CITY OF ALBUQUERQUE

August 14, 2020

RE: Kraemer Fields
2801 Karsten Court SE
Grading & Drainage Plan
Engineer's Stamp Date: 07/31/20
Hydrology File: M14D012J

PROJECT NO: 20067
DESIGNED BY: RJF
DRAWN BY: RJS
CHECKED BY: RJF
DATE: FEBRUARY 2021
SHEET TITLE
DETAIL LOT 2A-1
GRADING PLAN
SHEET NO:
C-3

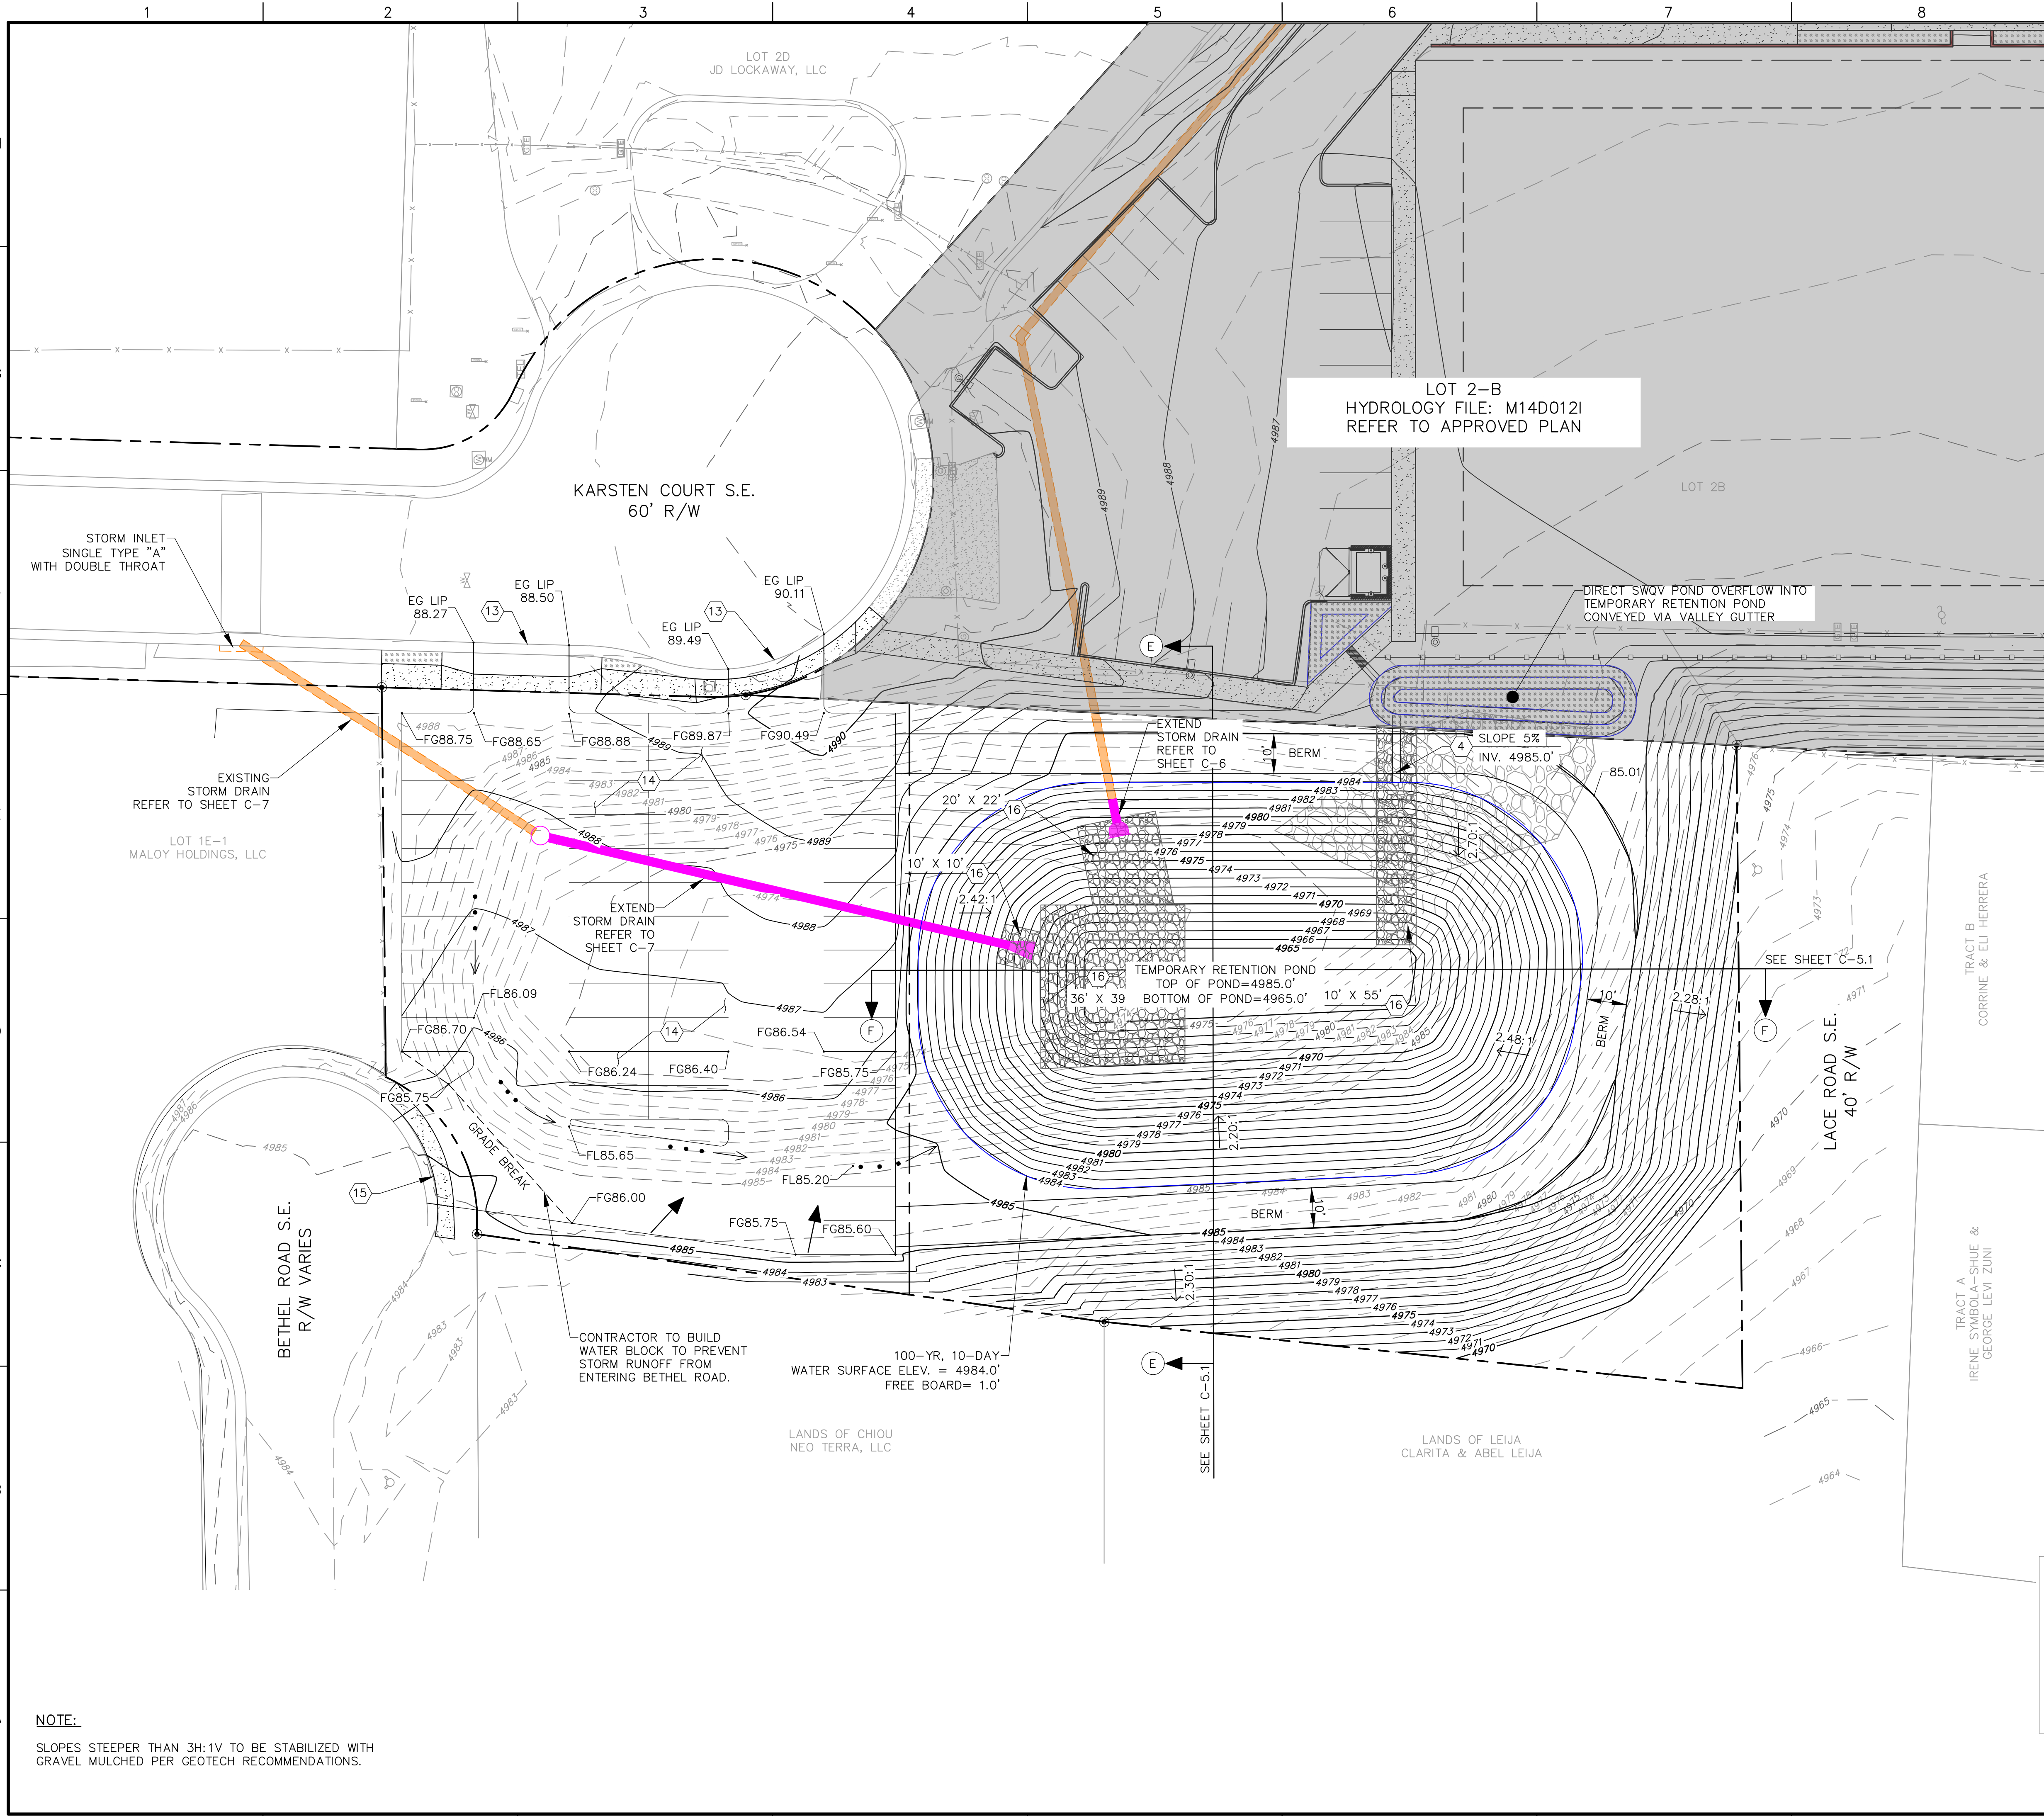
2. Sheet 1. Please correct the proposed ABQ Sports Complex drainage to reflect the approved Grading & Drainage Plan with Engineer's Stamp date of 11/14/19. Approval letter issued 11/21/19. (M14D012I). See below. If this site drains are being modified, than the Grading & Drainage Plan for this project ((M14D012I) will have to be resubmitted for approval by Hydrology.

3. Sheet 1. The proposed parking lot will not be able to street drain to Bethel Road. There is currently no capacity in the roadway to handle the runoff. Therefore you will need to install a water block per COA Paving Detail No. 2426 at the driveway entrance.

4. Sheet 1. The drainage from the proposed parking lot can be captured via storm inlet and connected to the proposed drainage system which outfalls to the newly shaped retention pond. This is what is indicated on Sheet 4.

5. Sheet 1. Please show the existing pipes that are to be removed and label them as being removed.
6. Sheet 1. Please provide all information on the proposed storm pipe system. (pipe invert elevations, MH top of rim elevations, inlet rim elevations,, and for the pipe sizes and lengths.

7. Sheet 1. Provide hydraulic calculations per Article 6-10 of the DPM for this proposed storm drain system, calculated along the Energy Grade Line; include both the HGL and EGLs in the table.

8. Sheet 1. Please provide a detail for the pipe outfall into the retention pond.
9. Sheet 2. Please provide the WSE of the 100 year 10 day volume in all sections.

TYPICAL
SECTION

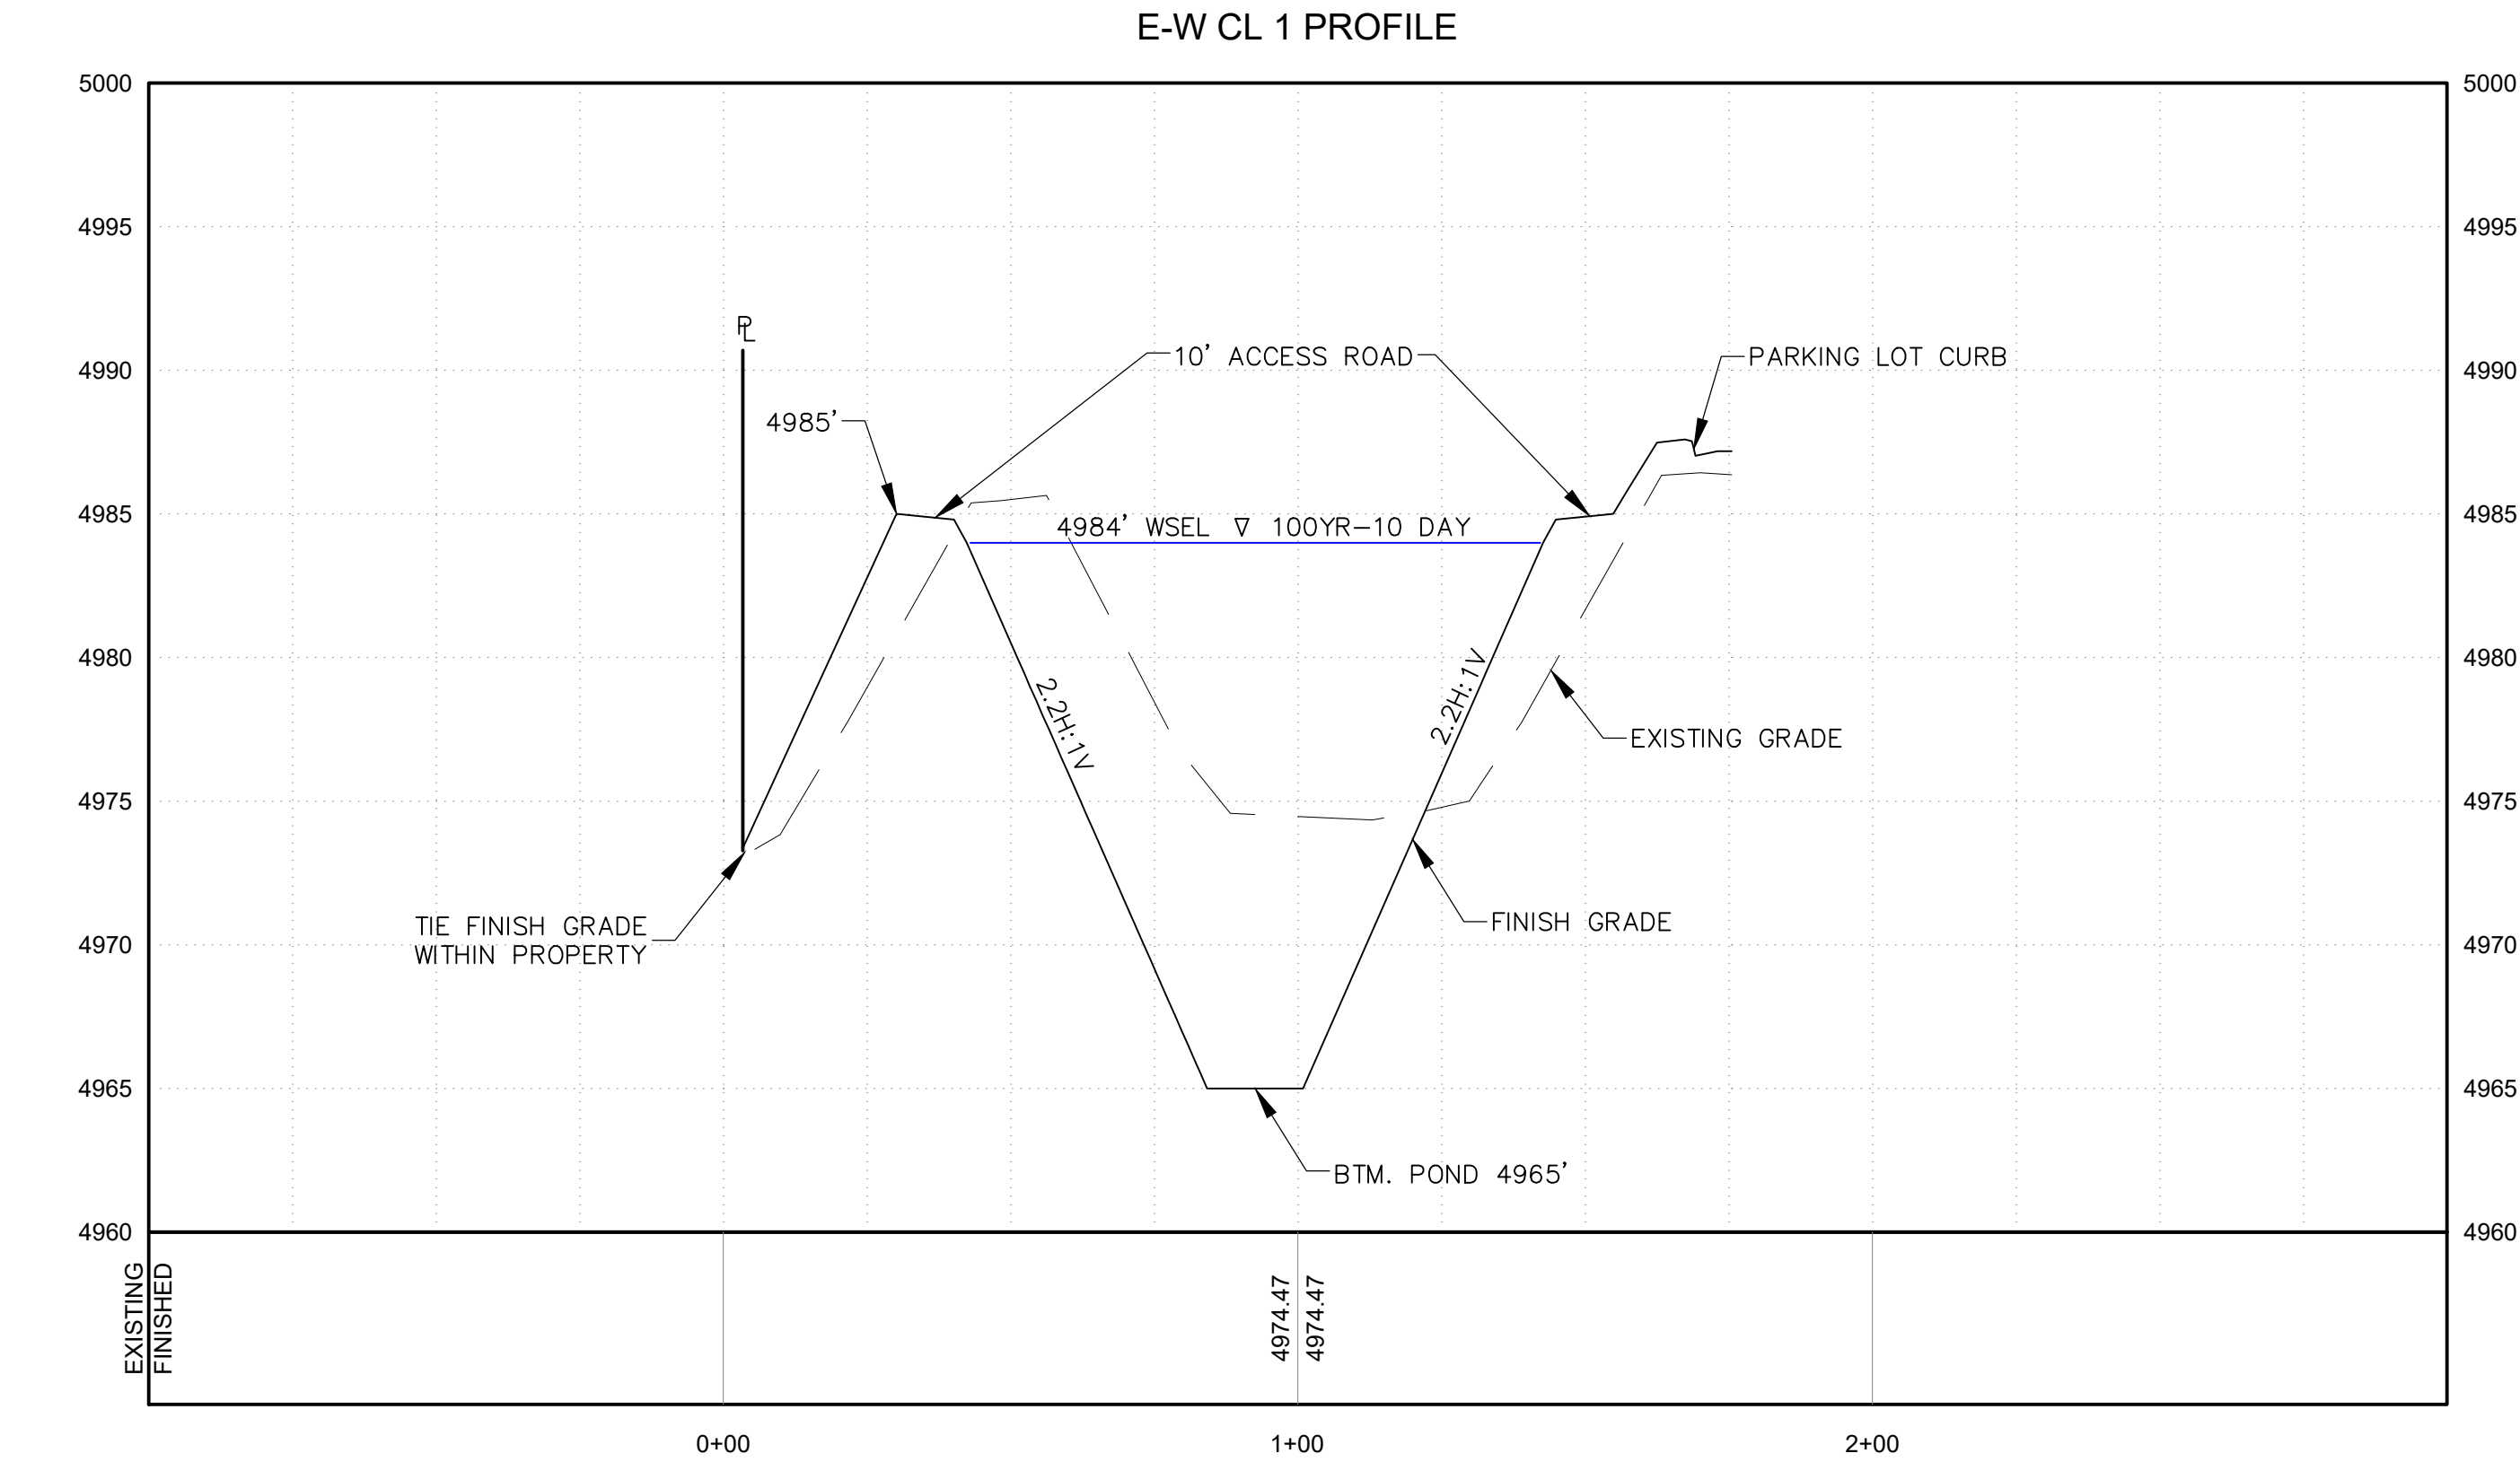
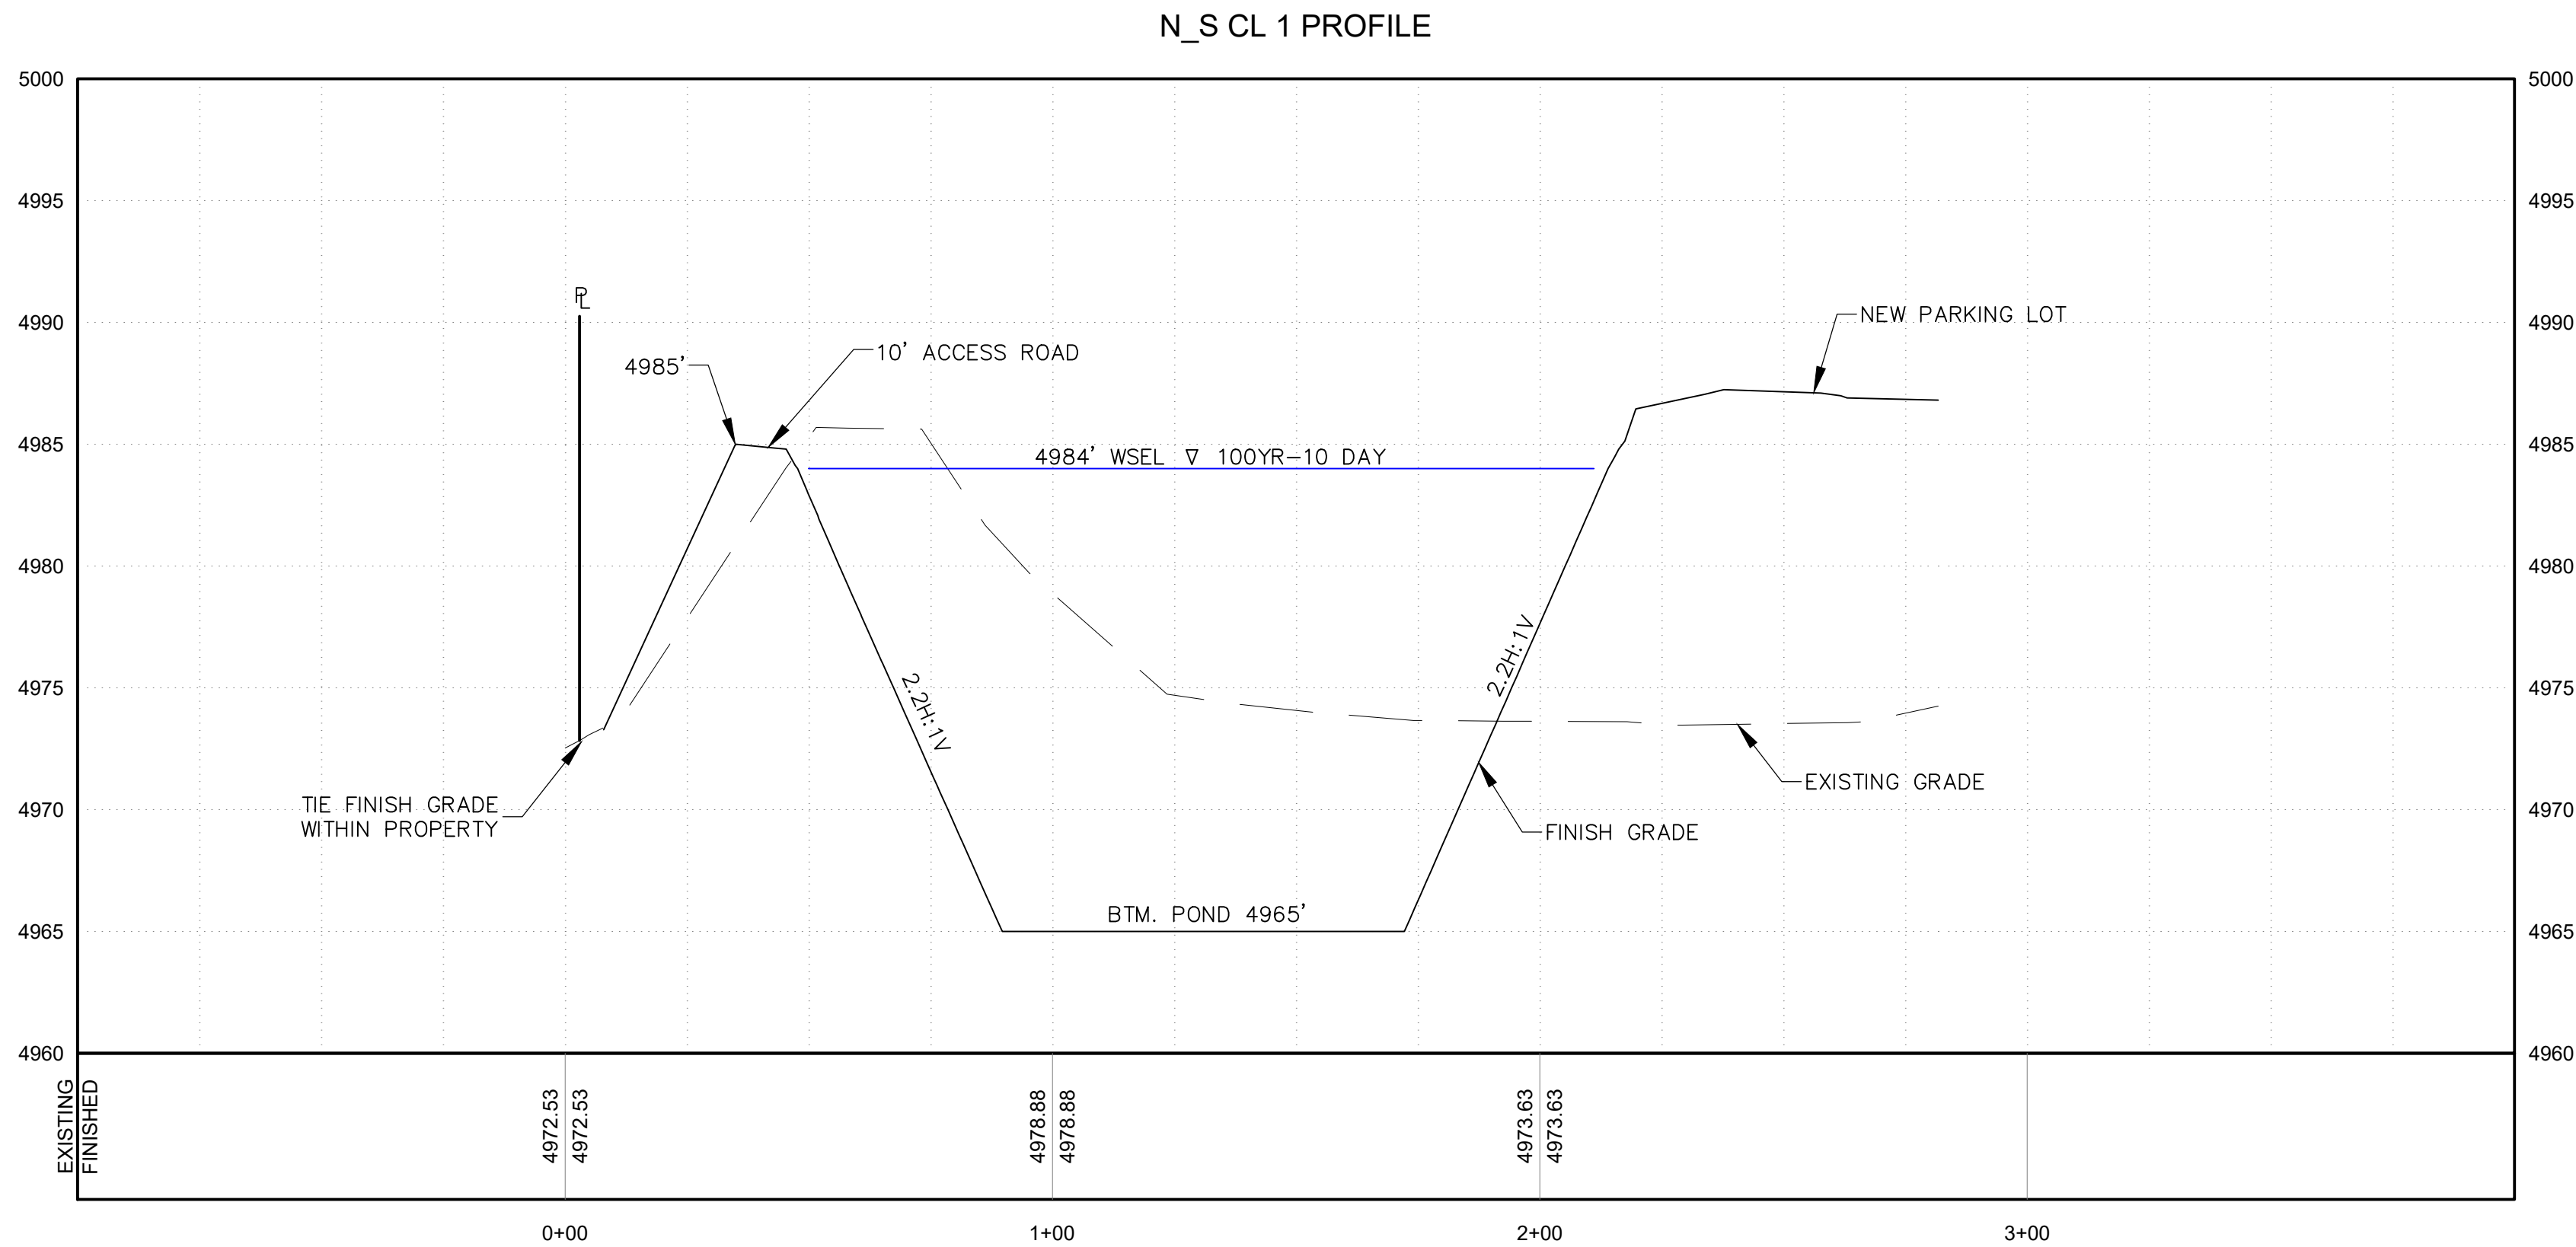
10. Sheet 2. .Please provide an approved City method to water proffing the retaining wall below the WSE of the 100 year 10 day volume.
11. Sheet 4. Basin 300 needs drain into the proposed storm drain as outlined in comment #4. Please show this.
